**Jacfin Pty Ltd - Submission on ESR Horsley Logistics Park
State Significant Development Application 10436
Site: 6 Johnston Crescent, Horsley Park**

We refer to State Significant Development Application 10436 (**Application**), by which ESR Developments (Australia) Pty Ltd (**Proponent**) seeks approval for the development of a new industrial warehouse and distribution precinct, including the construction and fit-out of six warehouses, on-lot stormwater, infrastructure and services (**Development**) on the Site.

RE: Objection to State Significant Development Application ESR Horsley Logistics Park

NOT FOR CONSTRUCTION

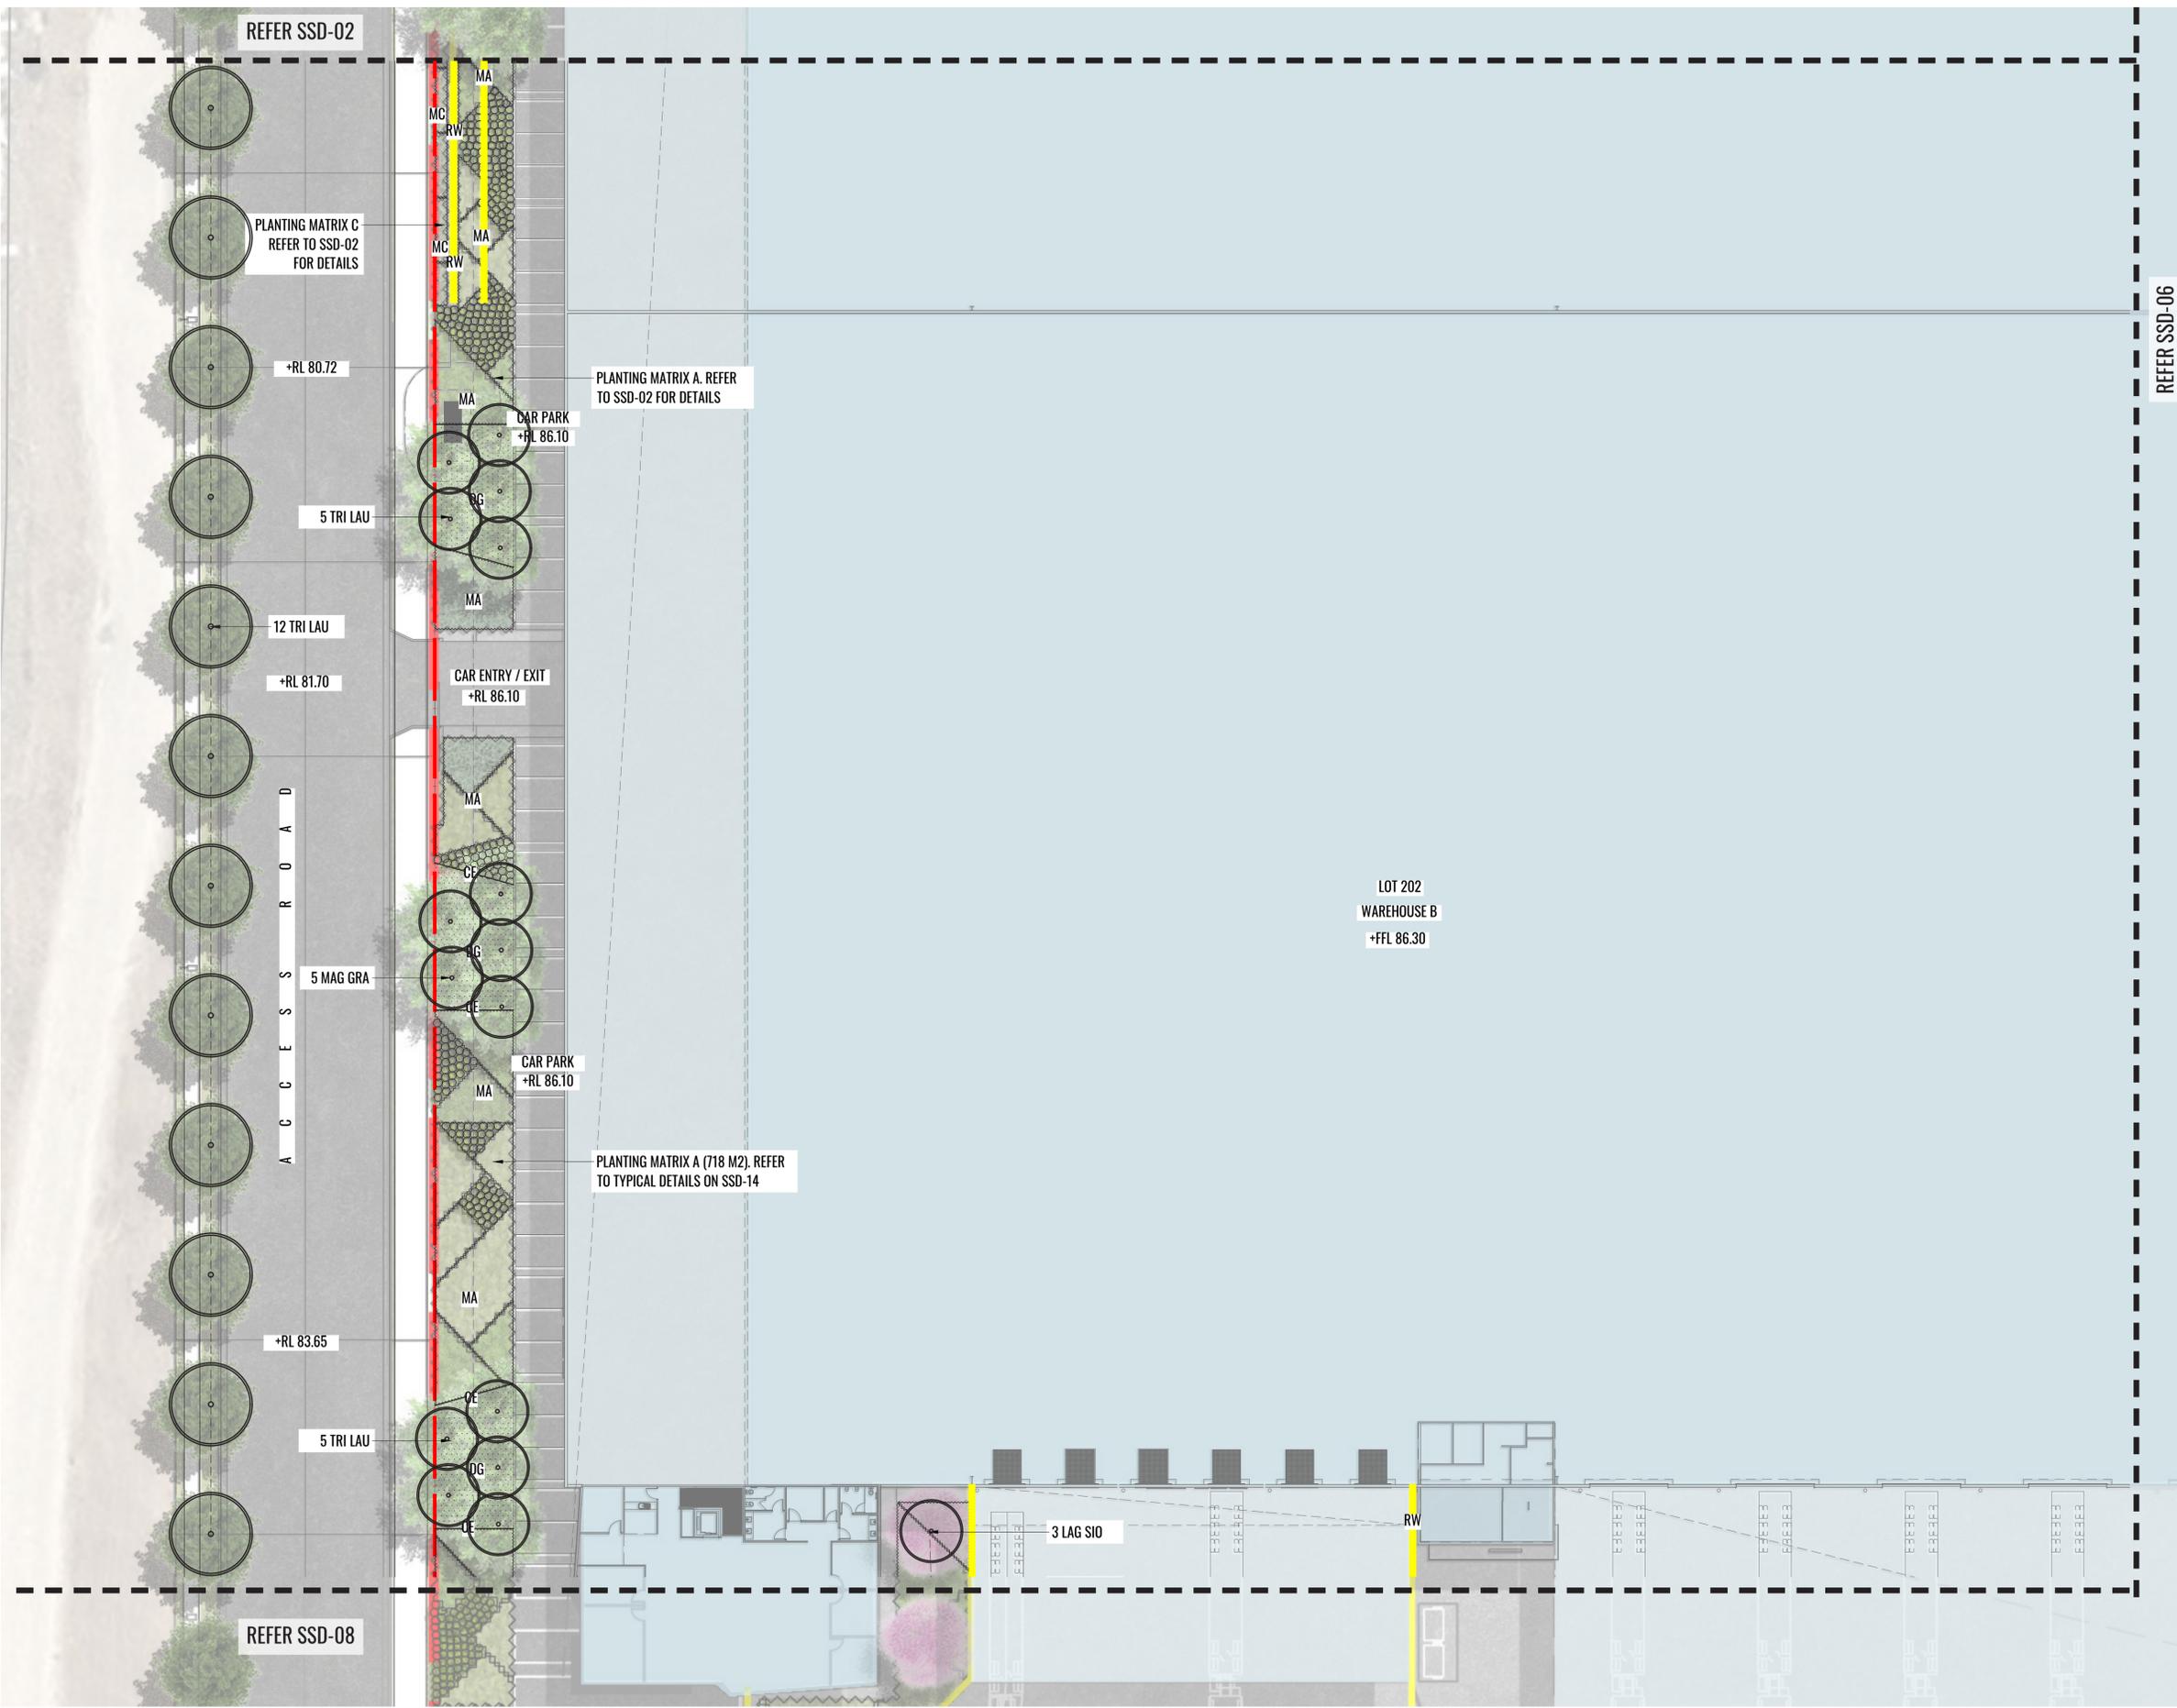
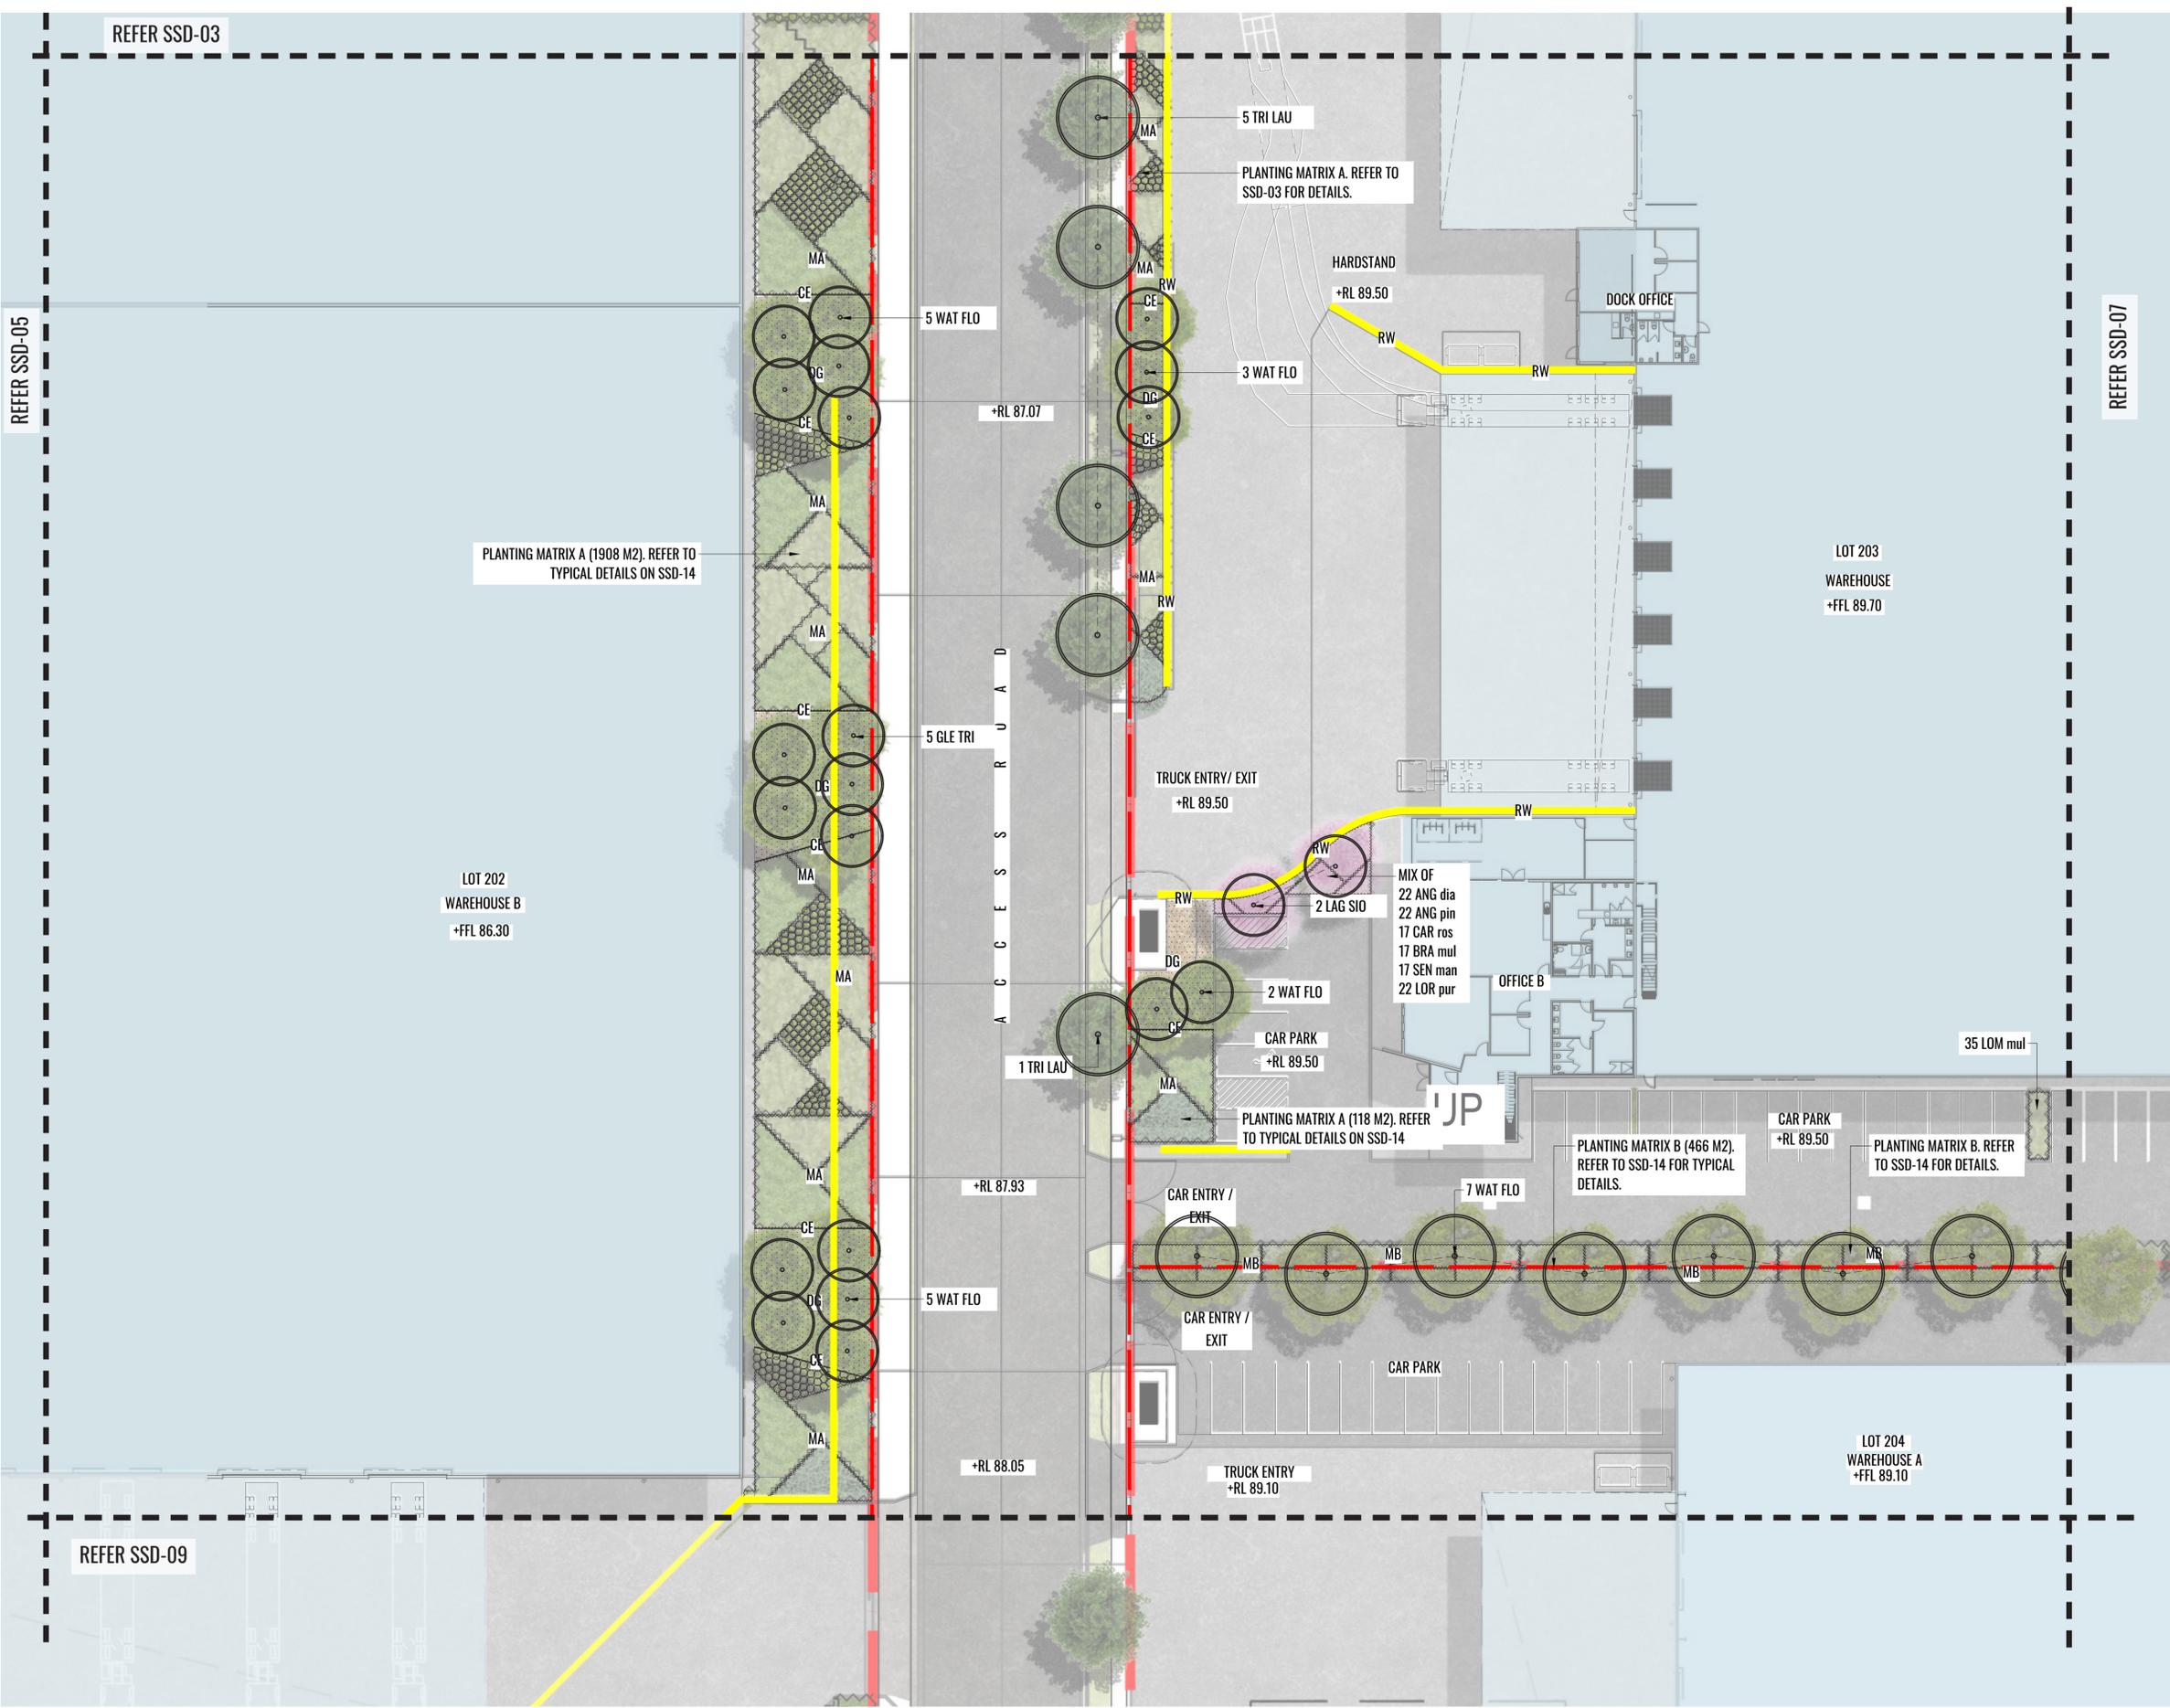
The Landscape Plans prepared by Geo Scapes (Drawing No. LDA-01 Revision C) show the proposed setback, however outline that "Southern landscape buffer (by others)". The landscape plan suggests that the landscaping of this buffer is provided under DA893.6/2013 and therefore does not need to be shown on this application. The maintenance of the landscaped setback will be the responsibility of ESR and should therefore be detailed on the EIS and be suitably conditioned. The EIS should also consider the existing and proposed height of the landscaping at the time of construction noting Commissioner Morris's comments in the judgement [70]:

The proposal needs to be amended to show a greater planted setback in line with the conditions of the Court. Furthermore the landscaping for the buffer needs to be considered as part of this EIS in the context of the buildings proposed to ensure the landscaping is dense and large enough to properly screen the proposed development.
